30 June 2022

Our Ref: 158607

RE: SSD-37558583 Lot 1 Bringelly Road Business Hub – Warehouse Facility at 5 Skyline Crescent, Horningsea Park

Appendix B: Detailed site survey by Land partners (2022)

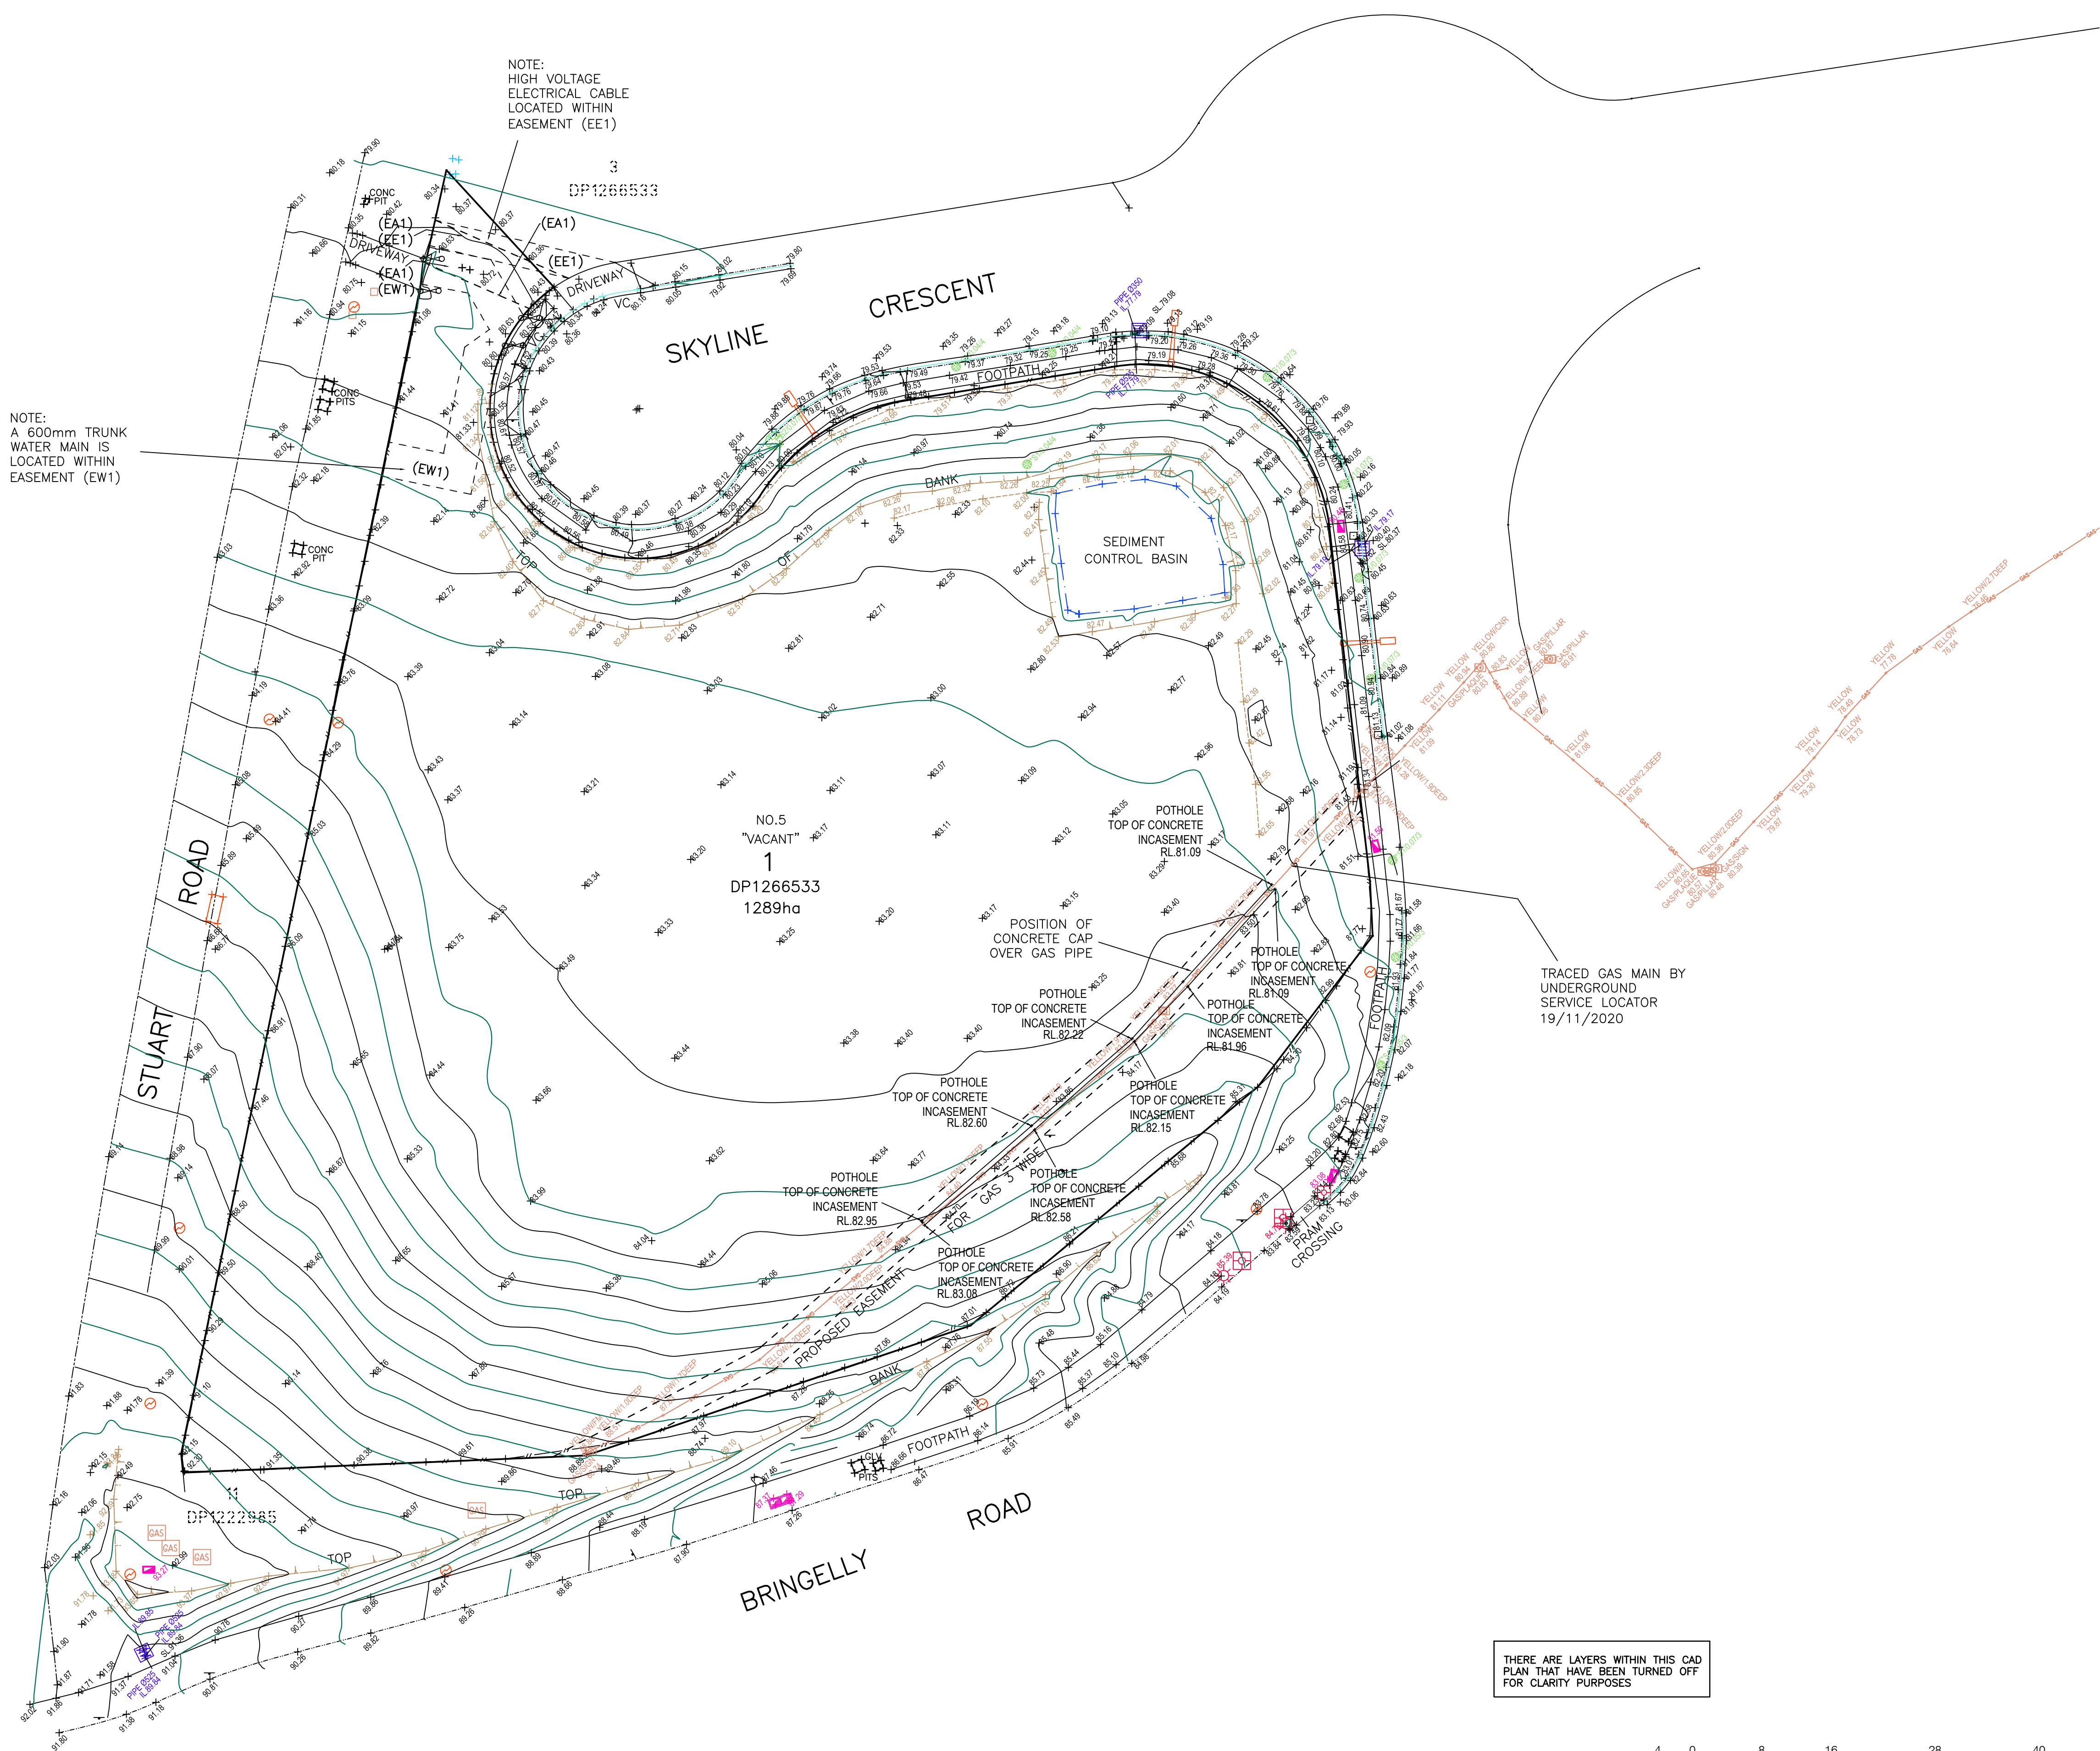
- A 600mm SCL trunk watermain traverses the north of the site and an associated stop valve is in the proposed truck carparking area.
- **The 600mm trunk watermain is a critical asset which feeds Carnes Hill Remainder Zone from Carnes Hill Reservoir.**
- Please ensure the proposed development zone of influence does not include the 600mm trunk water main in Skyline Crescent and the development site. If the development zone of influence includes this main, an Out of Scope Building Planning Approval may be required.
